(RR-037) ELAF: Use of public footpaths and proposed permissive paths / north-south greenway

Mrs Katherine Evans
Chairman – Essex Local Access Forum
3 November 2022

Drawing Title
LAND PLAN IN ACCORDANCE WITH REGULATION 5(2)(i) OF THE INFRASTRUCTURE PLANNING (APPLICATIONS: PRESCRIBED FORMS AND PROCEDURE) REGULATIONS 2009 SHEET 2 OF 9

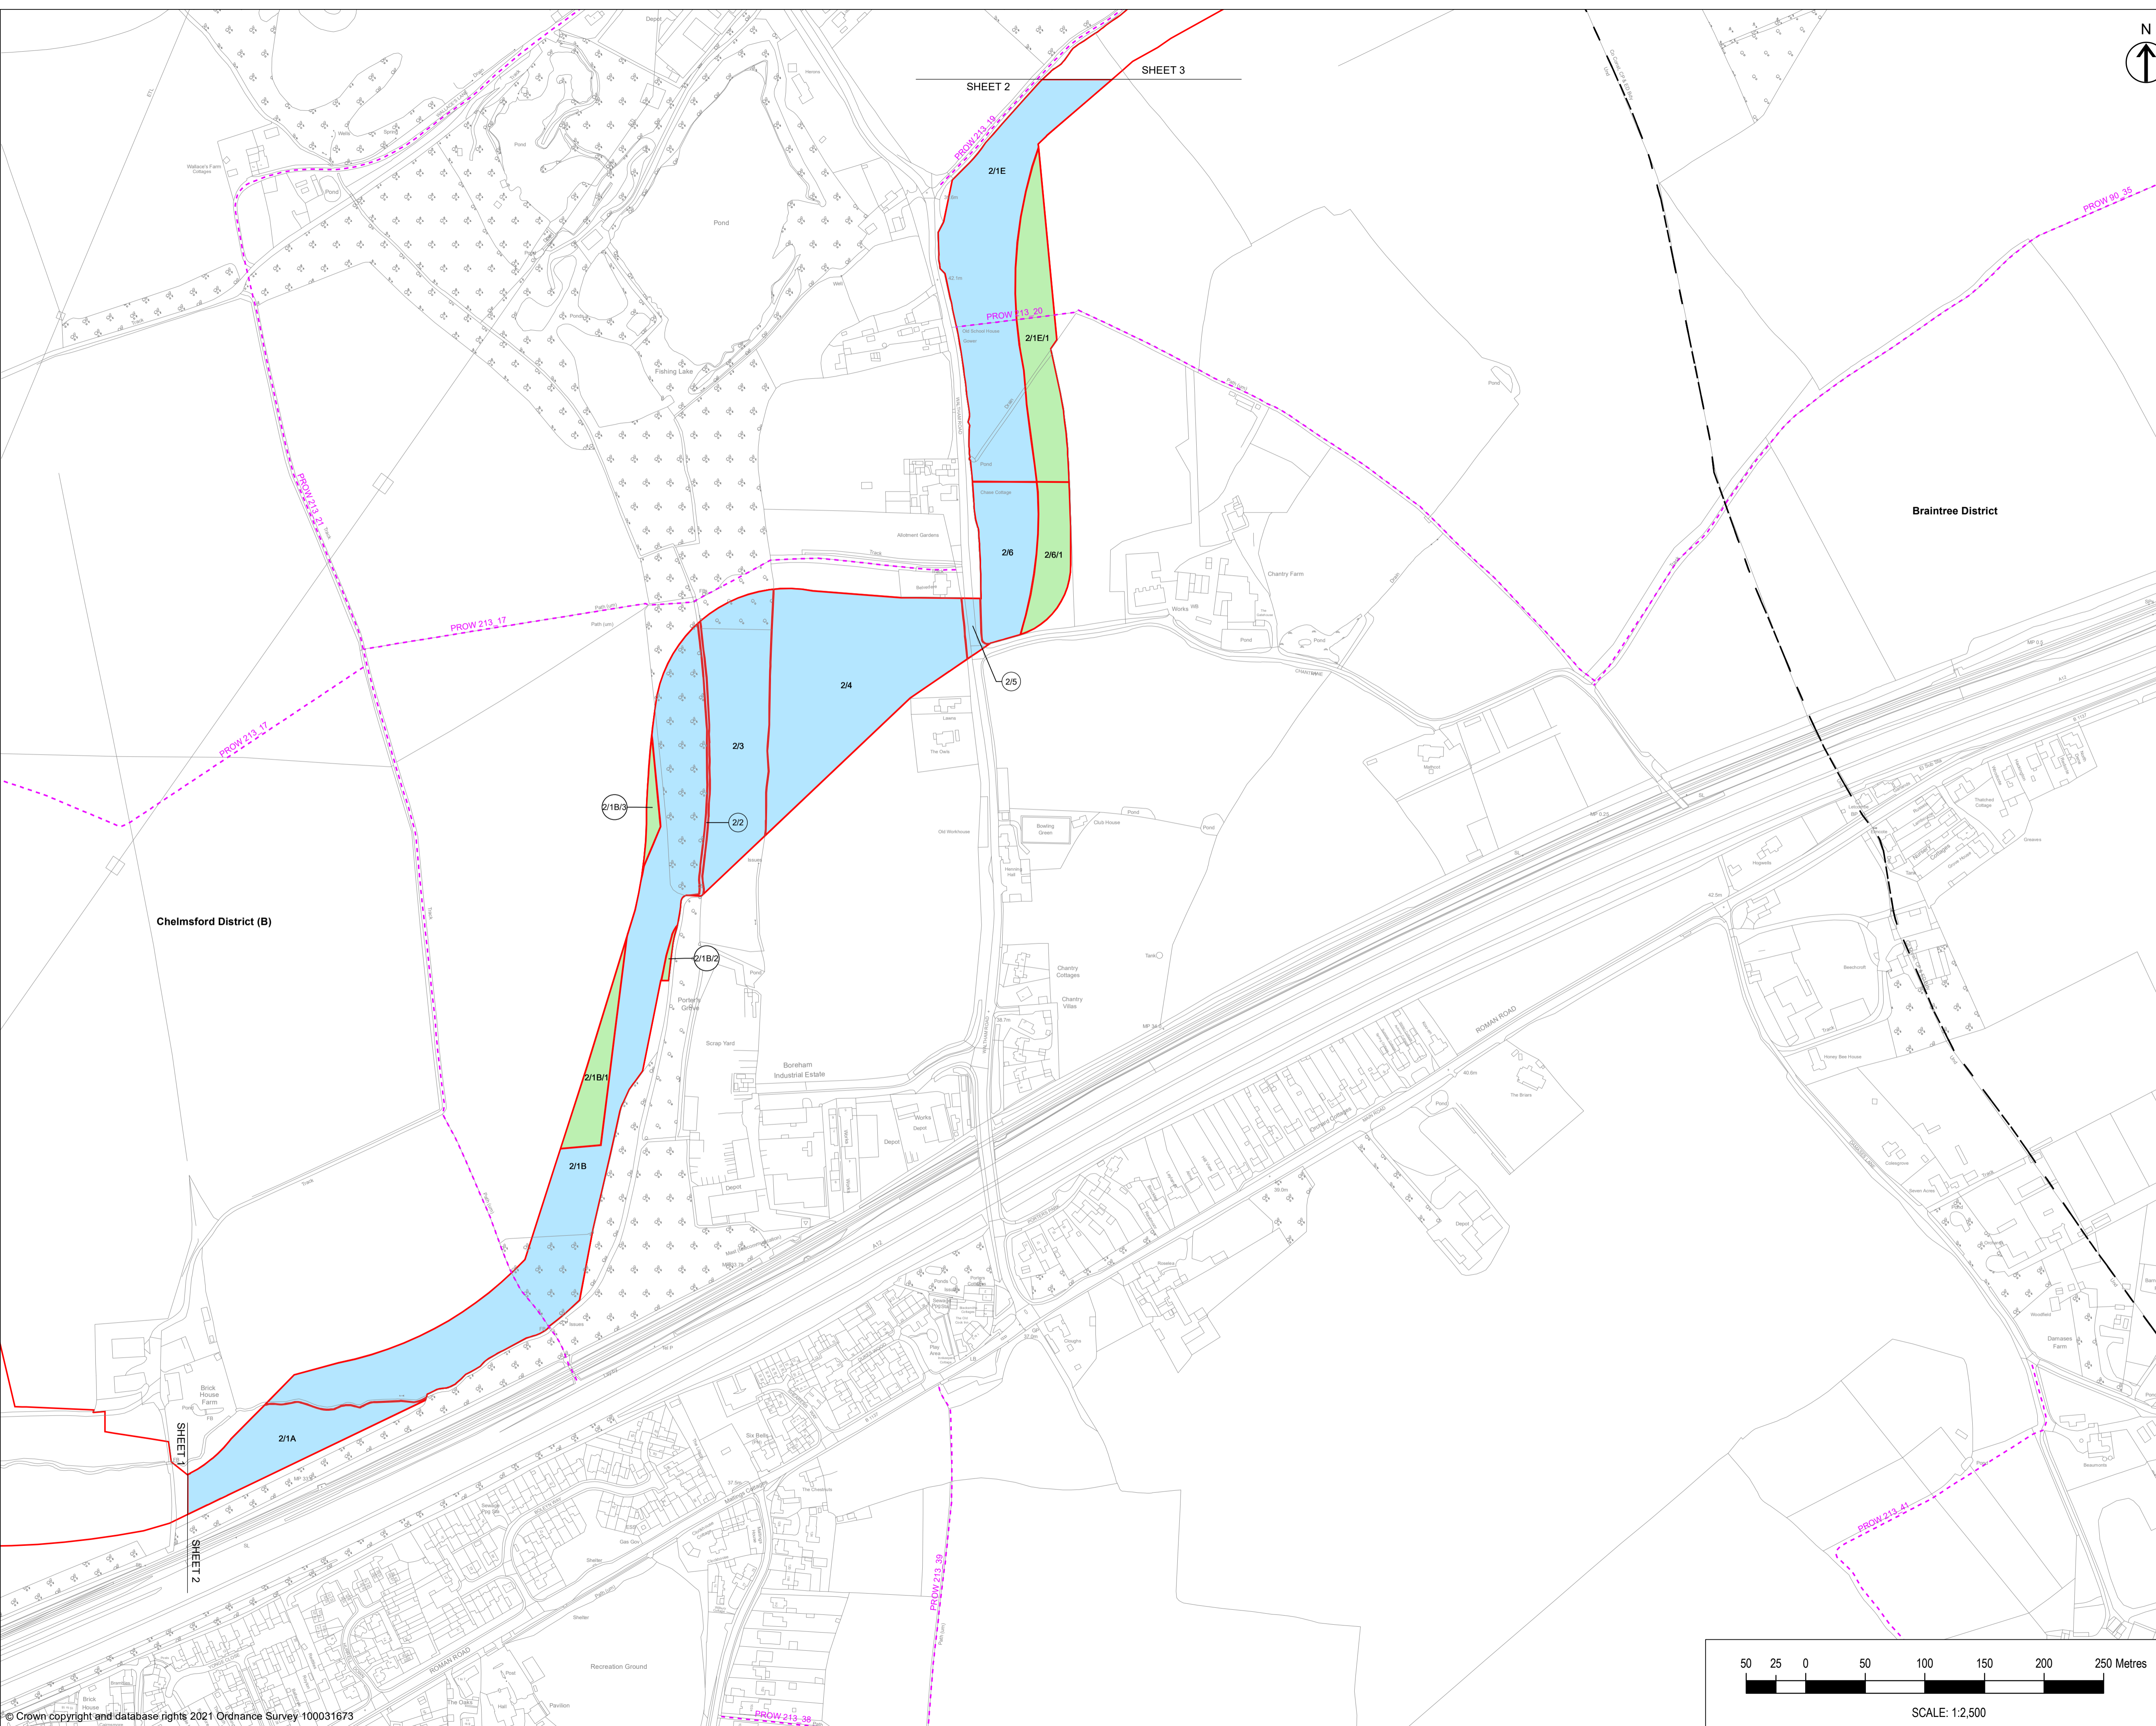
(ii) At the southern end the final western sections of the footpath connections to Waltham Road – Boreham footpath 18 or 19 [213_18 or _19] are outside the order limits so would require the permission of the landowner. The other connection along the cable route would also require landowner permission. See Land Plan sheets 3 & 2.

Drawing Title
LAND PLAN IN ACCORDANCE WITH REGULATION 5(2)(i) OF THE INFRASTRUCTURE PLANNING (APPLICATIONS: PRESCRIBED FORMS AND PROCEDURE) REGULATIONS 2009 SHEET 7 OF 9

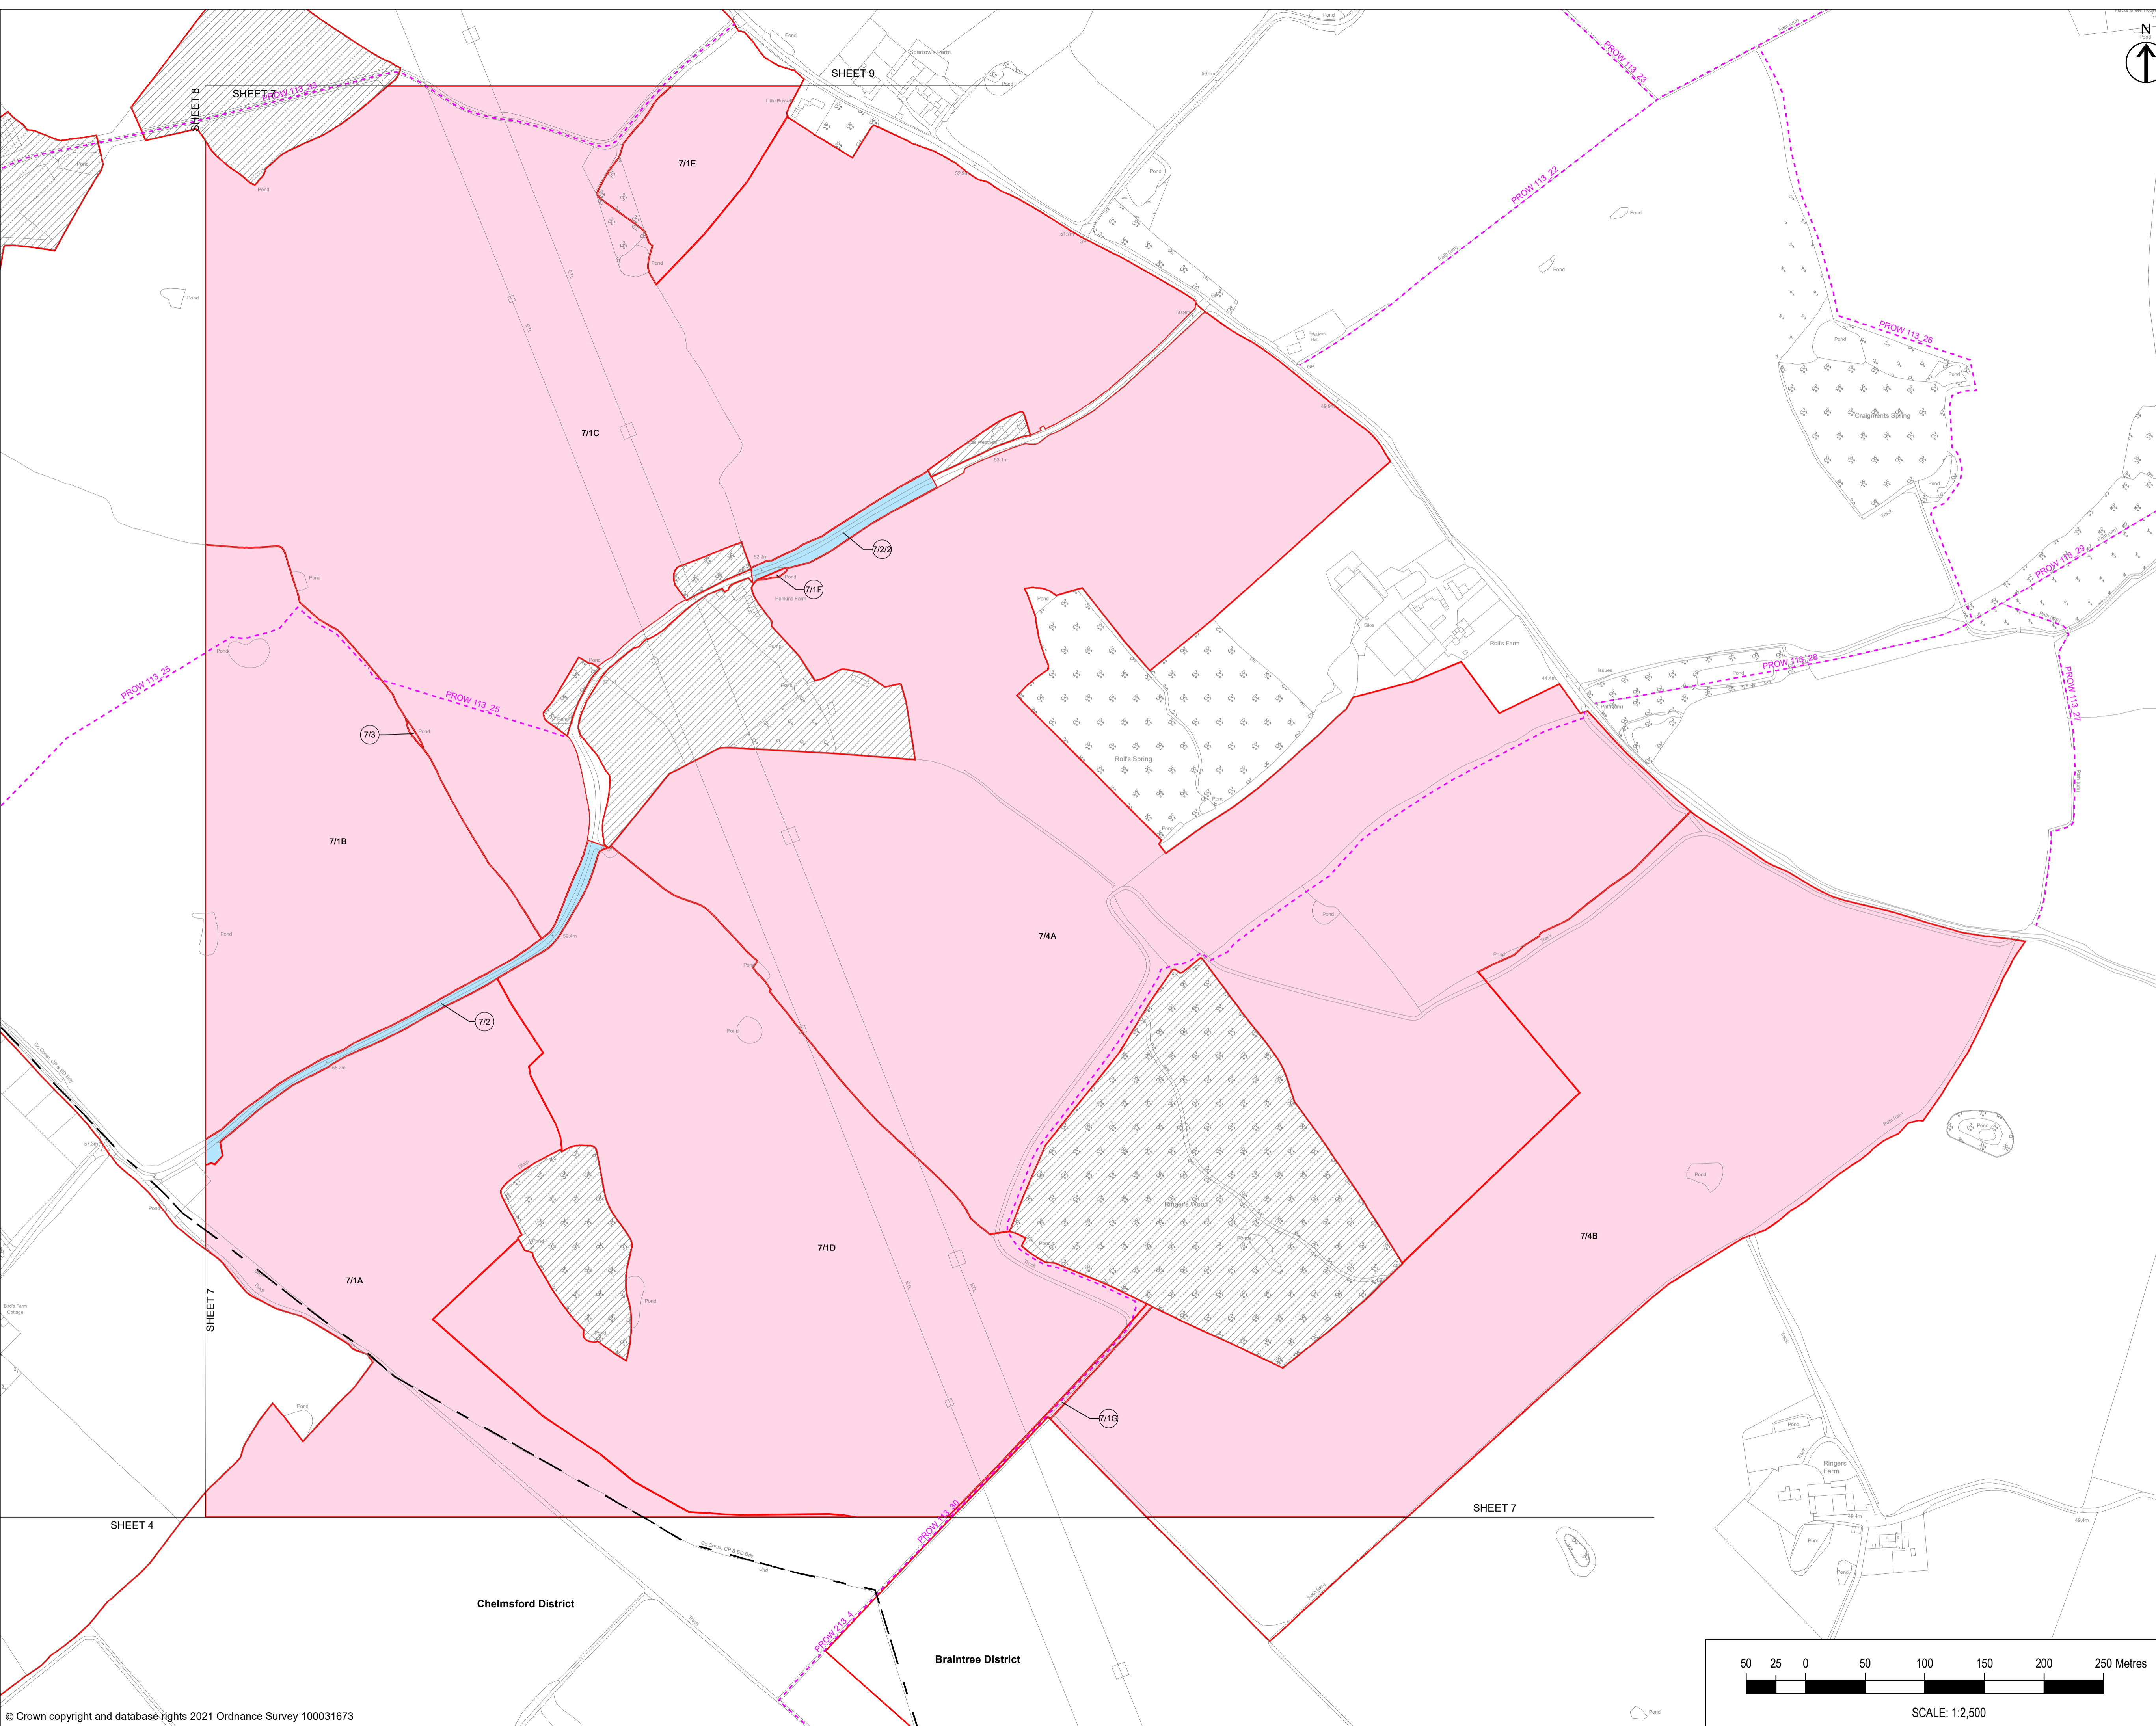
(i) At the northern end, a connection to the permissive paths for cyclists and horse-riders, that is inside the pink wash land, could be to Rolls Farm Lane / Sparrows Farm Lane, which is a public road at the northern termination of Terling footpath 33 [113_33]. See Land Plan sheets 7 & 9.
